# KITTITAS COUNTY FIRE MARSHAL'S OFFICE

April 1, 2013

Re: A. Marchel Short Plat (SP-13-00004)

A. MARCHEL SHORT PLAT
 A PORTION OF THE WEST 1/2 OF SECTION 14,
 TOWNSHIP 17 NORTH, RANGE 20 EAST, W.M.,
 KITTITAS COUNTY, WASHINGTON

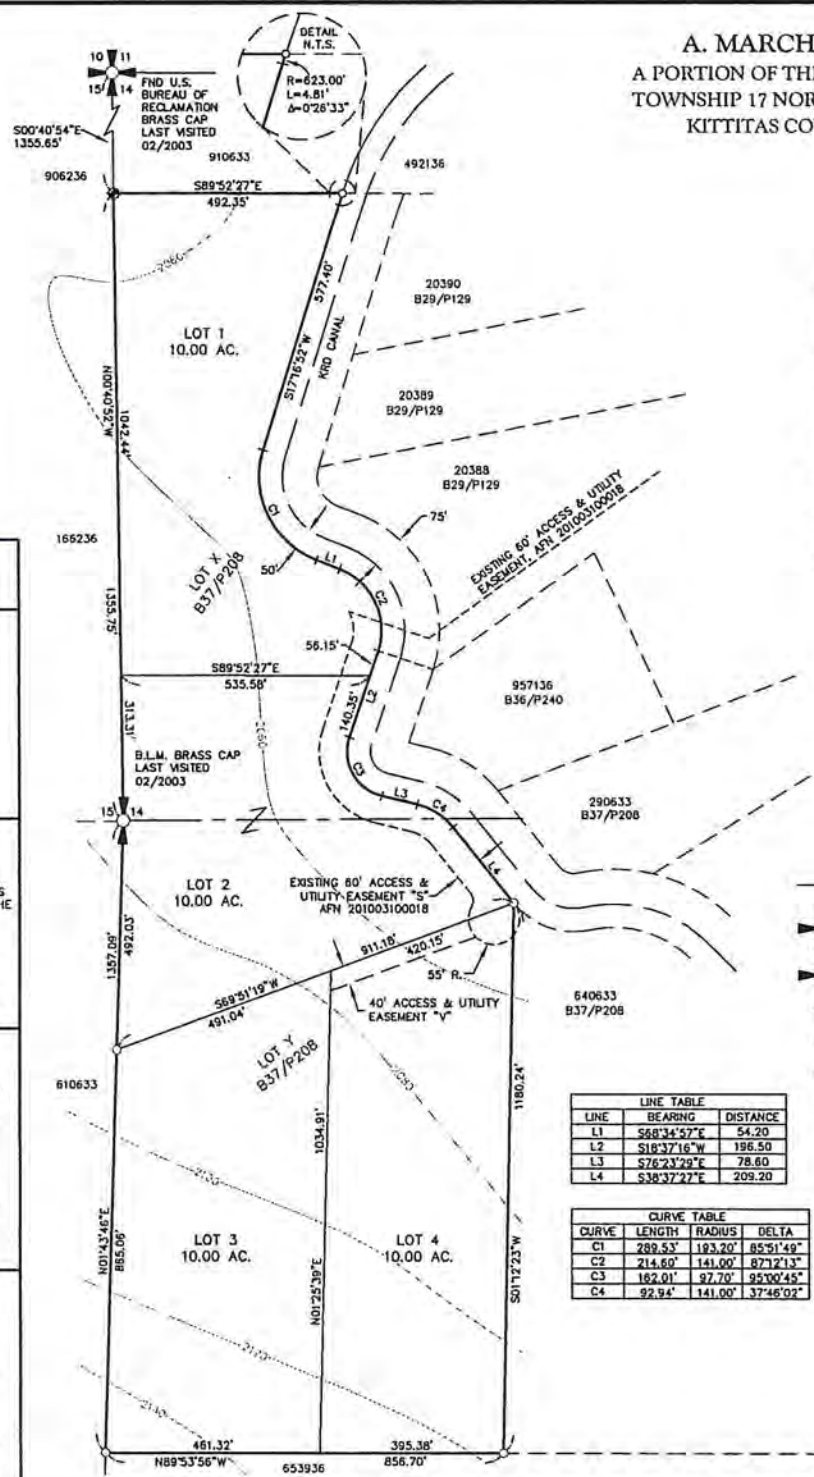
- The access to the property appears to cross over the KRD canal. If a bridge is currently existing in place, it is not required to be brought up to County Code, however if a new bridge needs to be built, or any structural work needs to be done to an existing bridge, it must be approved through a permit from the Fire Marshal's Office.
- All future development must comply with the International Fire Code.
